**CHENNAI METROPOLITAN DEVELOPMENT AUTHORITY**  
Thalamuthu Natarajan Building, No.1, Gandhi Irwin Road, Egmore,  
Chennai - 600 008  
Phone : 28414855 Fax: 91-044-28548416  
E-mail: mscmda@tn.gov.in  
Web site: www.cmdachennai.gov.in

**(Development Charges Letter)**

File No. : **CMDA/PP/NHRB/S/0403/2022**

Sub: CMDA – Area Plans Unit - ‘B’ Channel (South) - The Planning Permission Application is for the proposed construction of Stilt Floor + 3 Floors (14.0m height) Office use (Commercial) cum single Dwelling unit at First and Second floor Part at Plot No.164, Defence Officers Colony 13th Cross Street, Nandambakkam, Chennai – 600 062 Comprised in Old S.No.163, New S.No. 163/35 of Nandambakkam Village Within the Limits of Greater Chennai Corporation – Remittance of DC & Other charges – DC advice Sent – Reg.

Drawing file: PP-NHRB-S-0403-2022 / ApprovedPlan.pdf

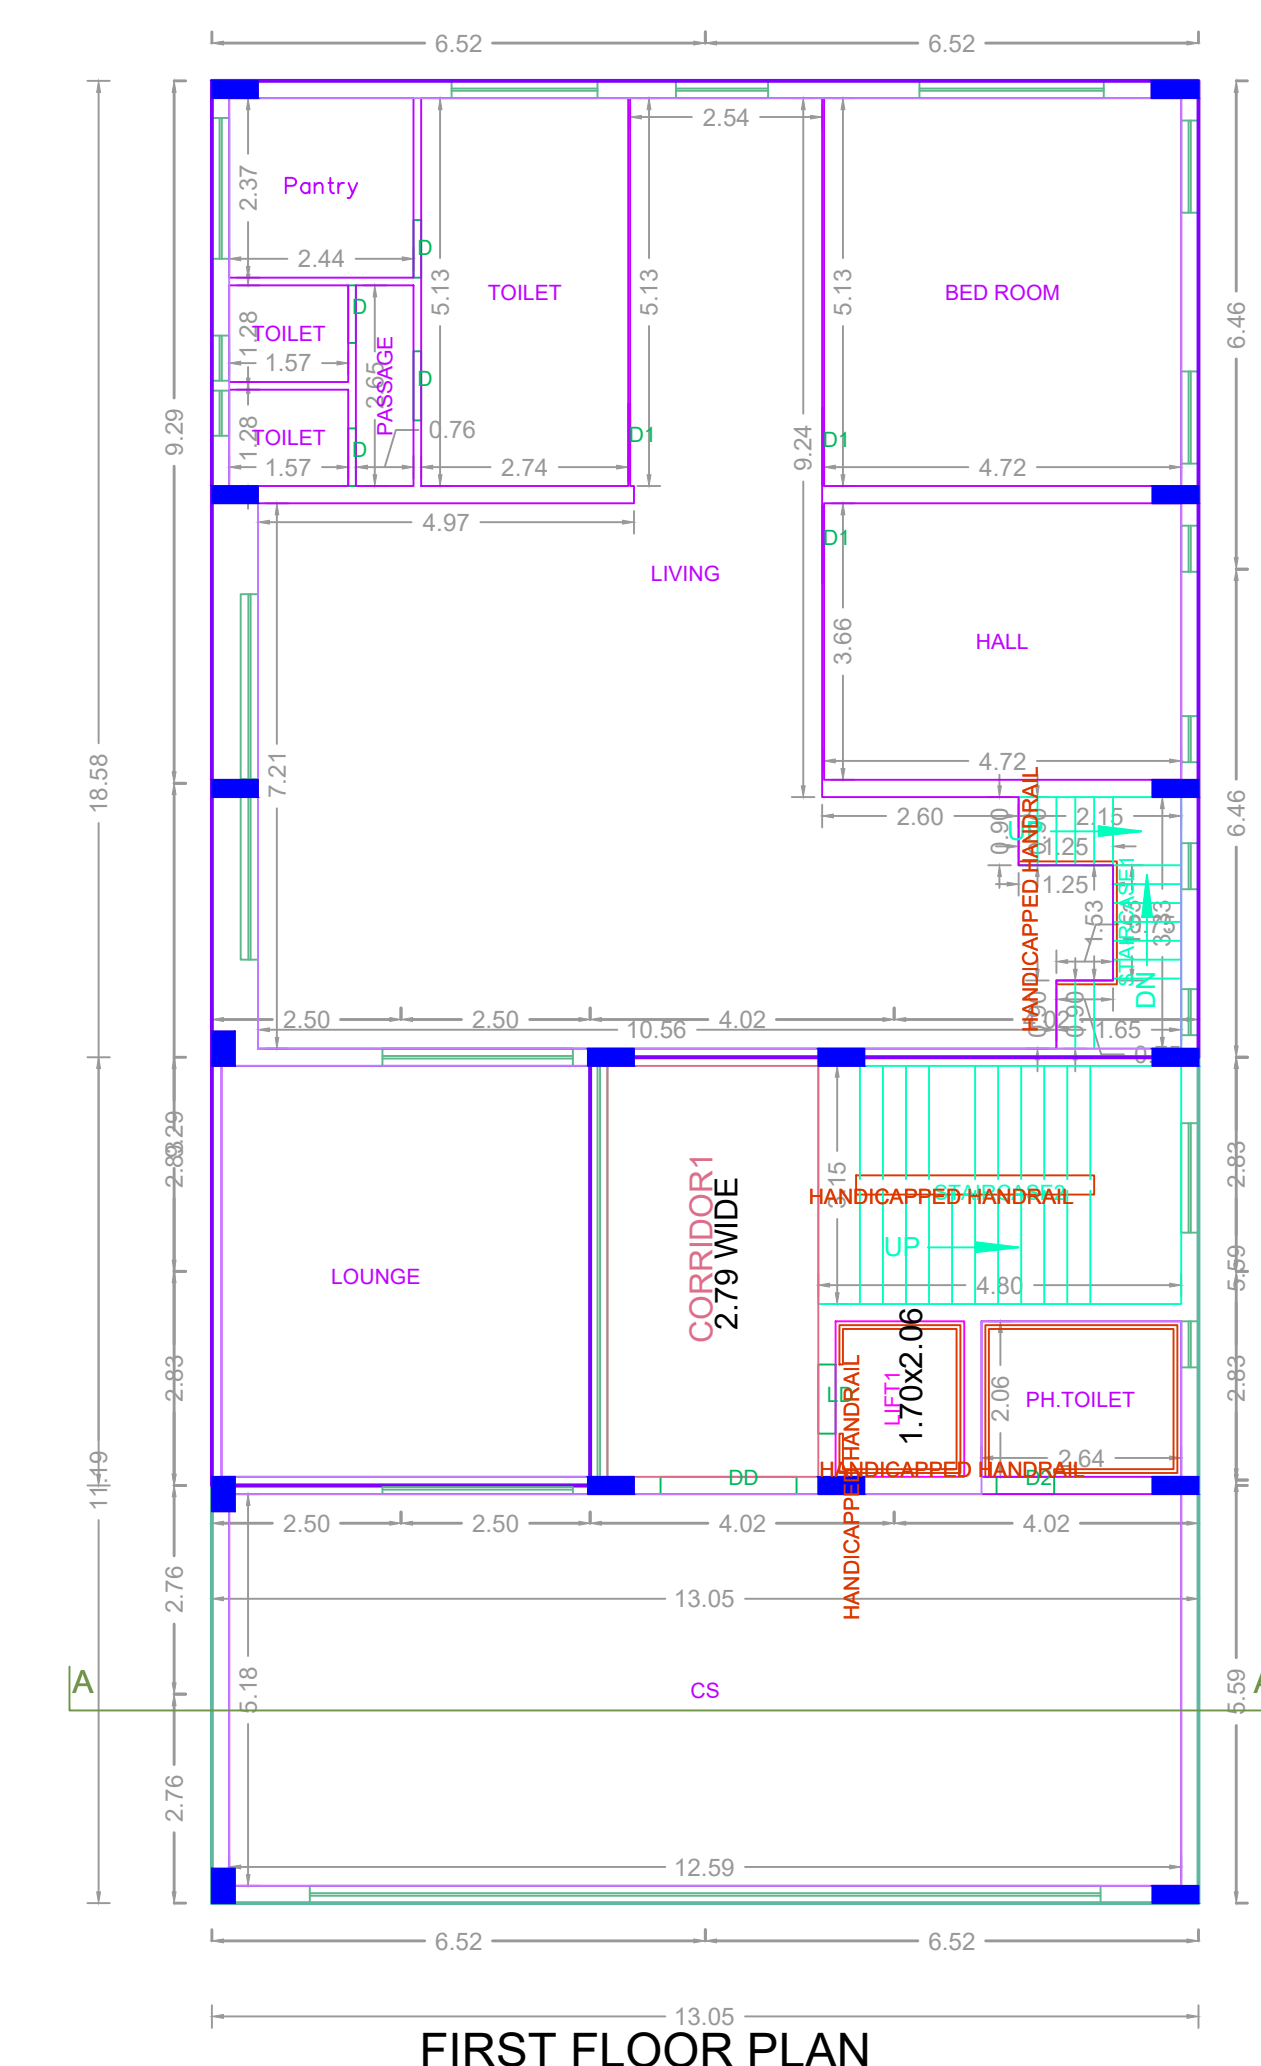
1. Office area in first and Second floor plan to be clearly named/shown as "Office"
2. The Open space shown next to Open lounge in Second floor plan to be included in FSI area
3. Second floor residential unit Staircase to be shown correctly in Second floor plan
4. In Terrace floor plan: Low Terrace to be correctly shown as "Low Terrace at Second Floor"
5. Parking Statement to be corrected (Car Parking: Required-9Nos, Available-9Nos; Tw parking: Required-17Nos, Available-29Nos)
